## Application for a Non-Material Amendment Following a Grant of Planning Permission

demolition of the existing dwelling and erection of a two storey plus lower ground floor level detached dwellinghouse with integral garage, associated refuse/recycling store, cycle store, amenity space and provision of 2no.off street parking spaces

22/0501/ful

APPROVED LOFT FLOOR

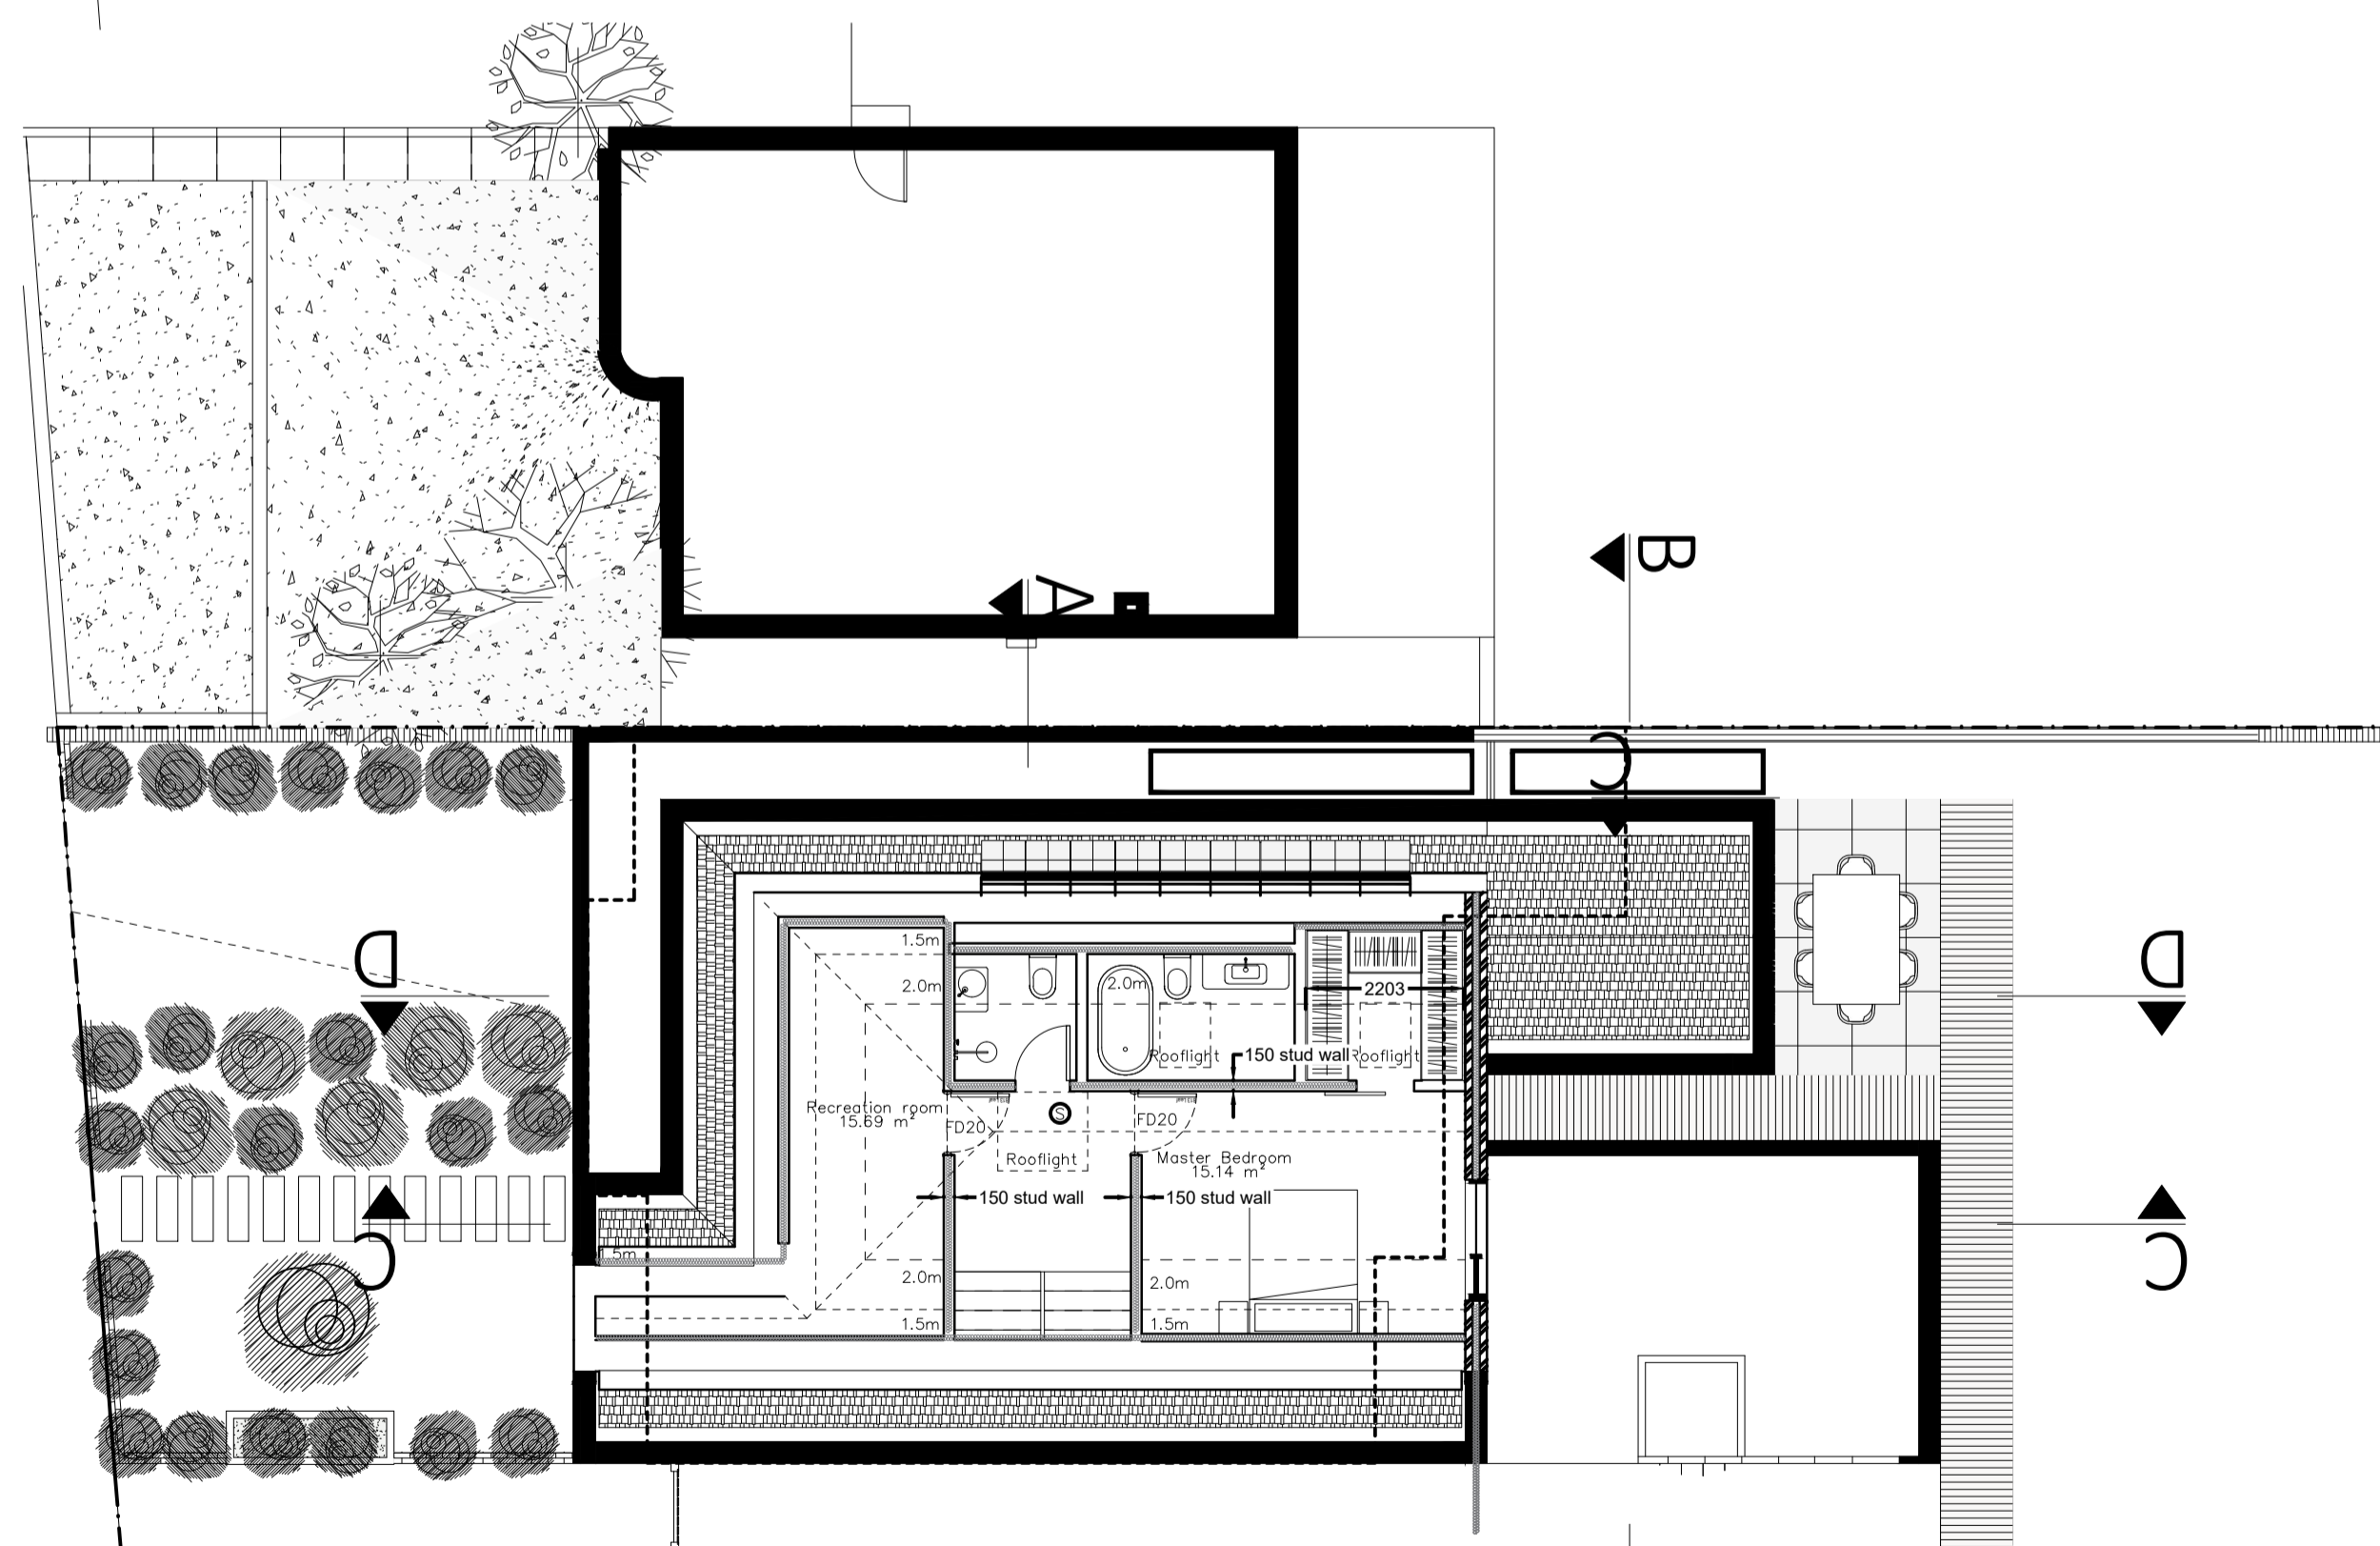
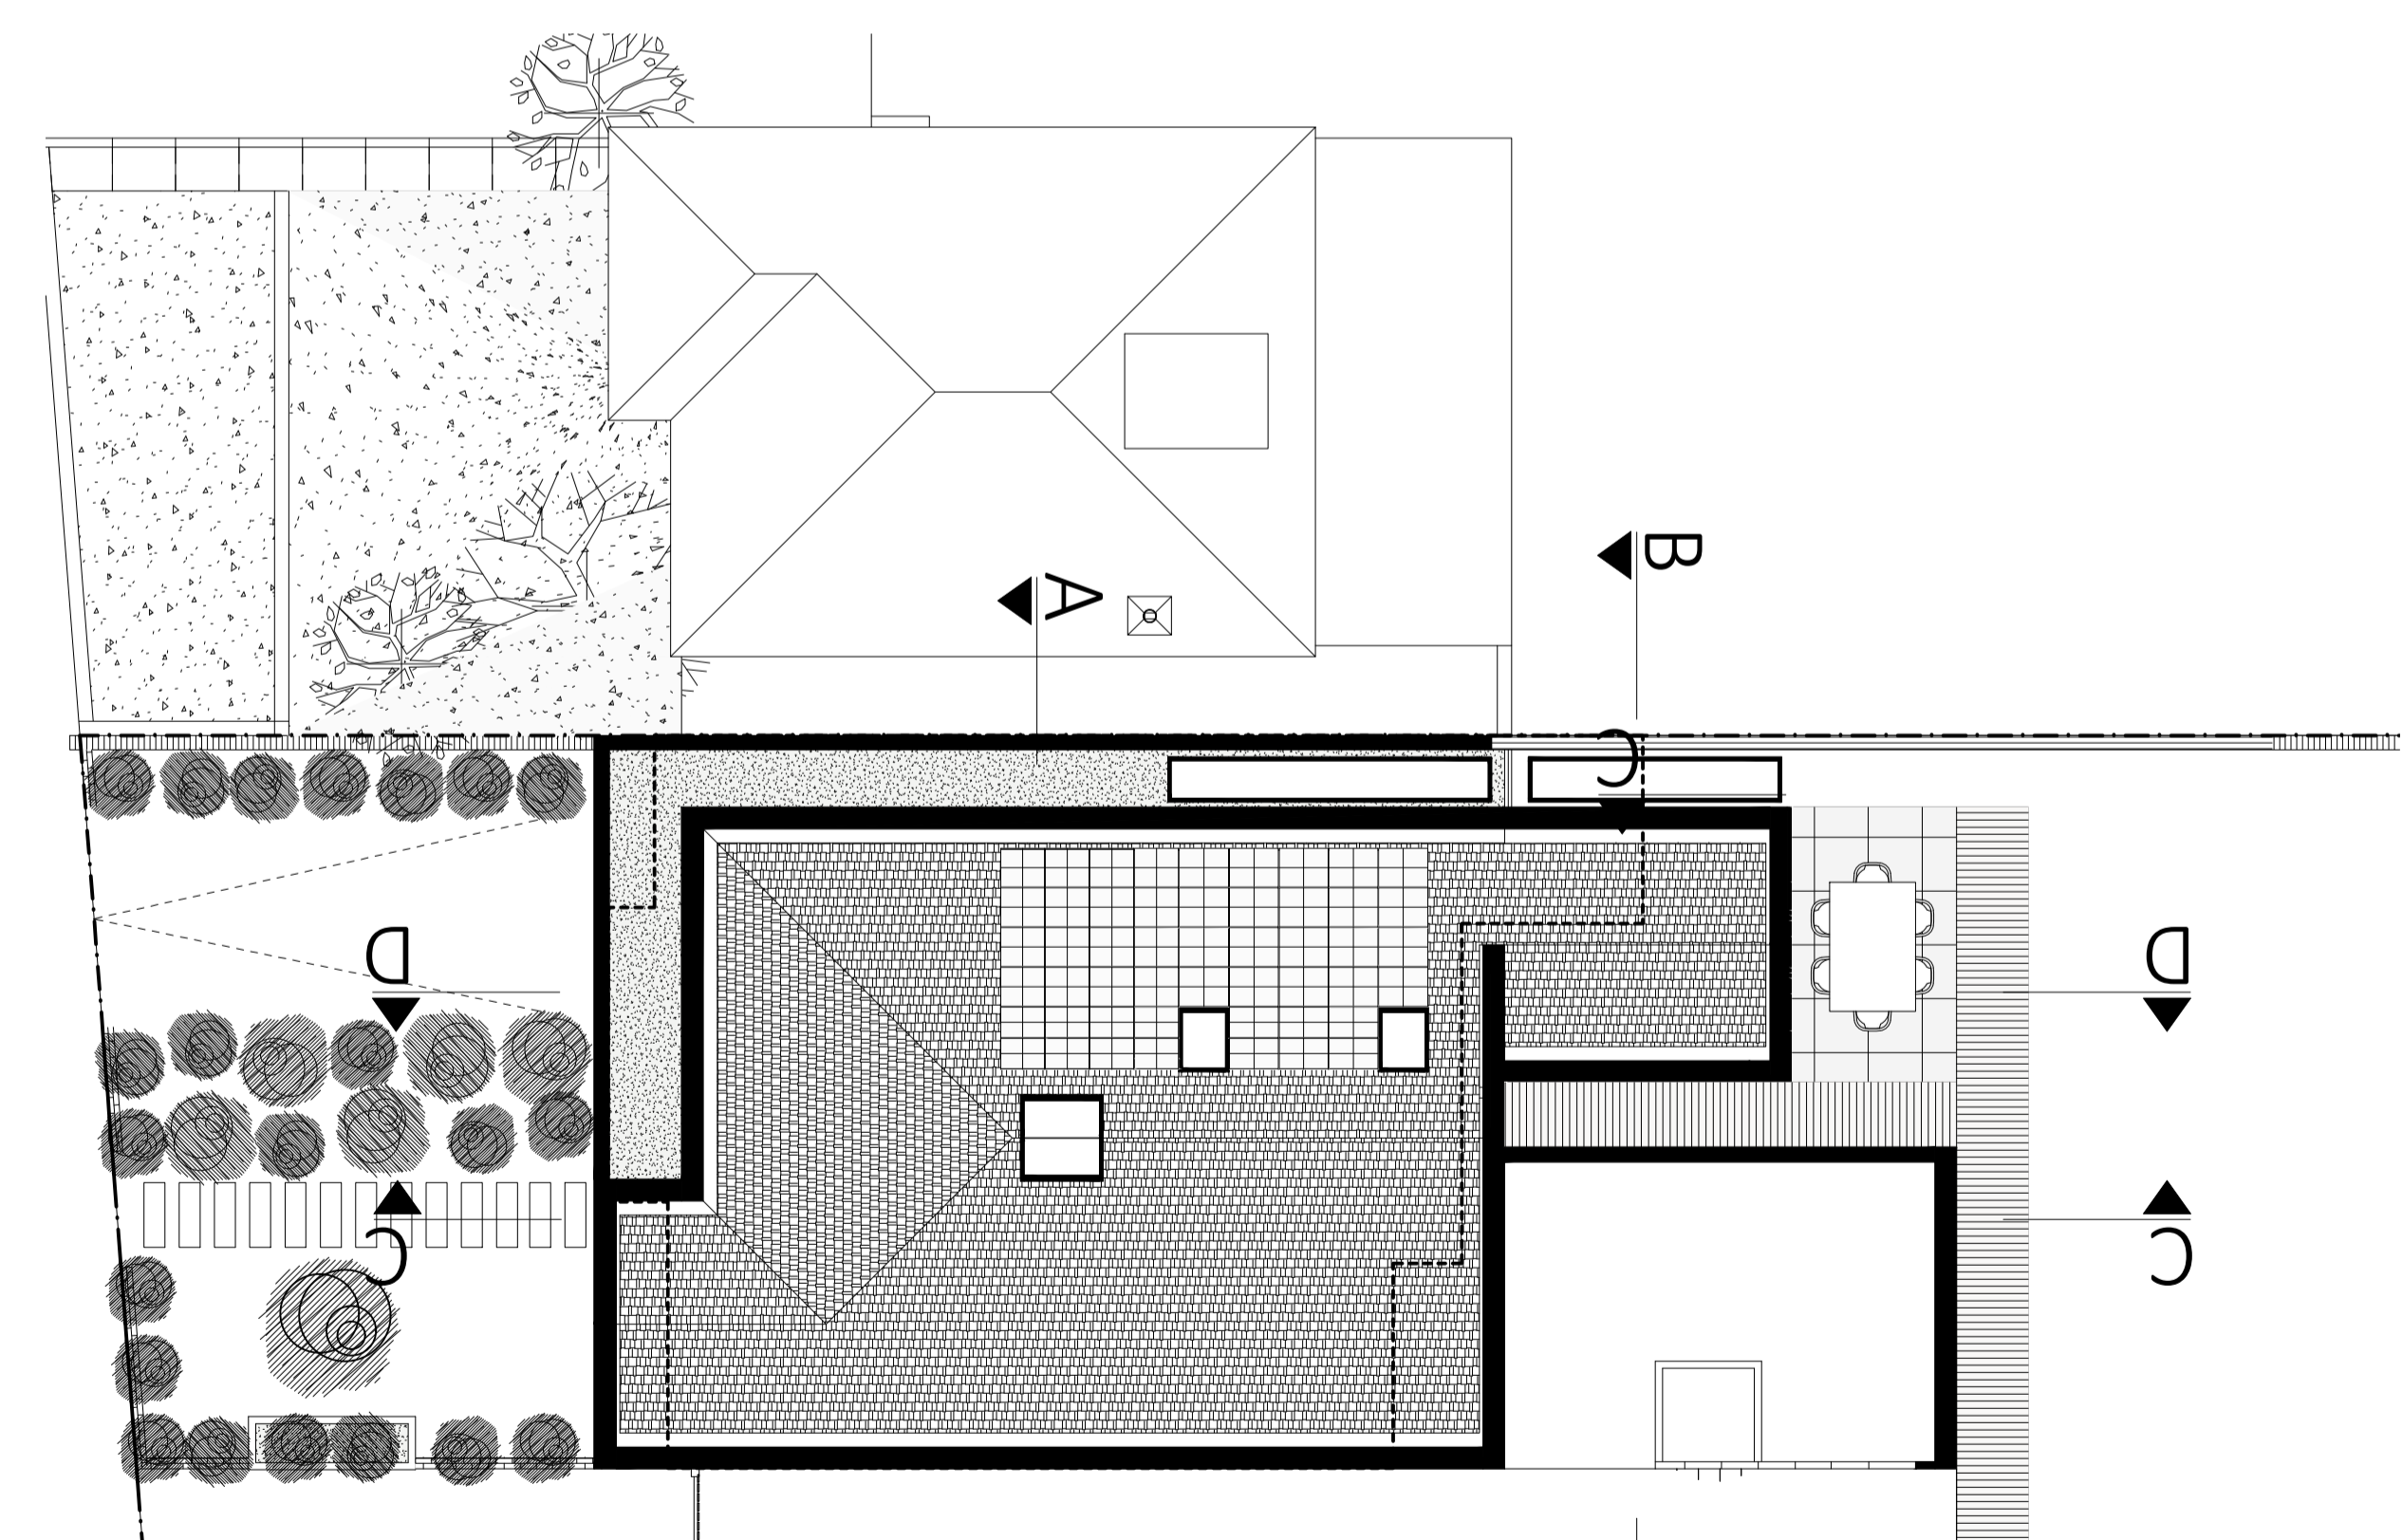
the back addition part of the build has been extended by 500mm

to rectify the build
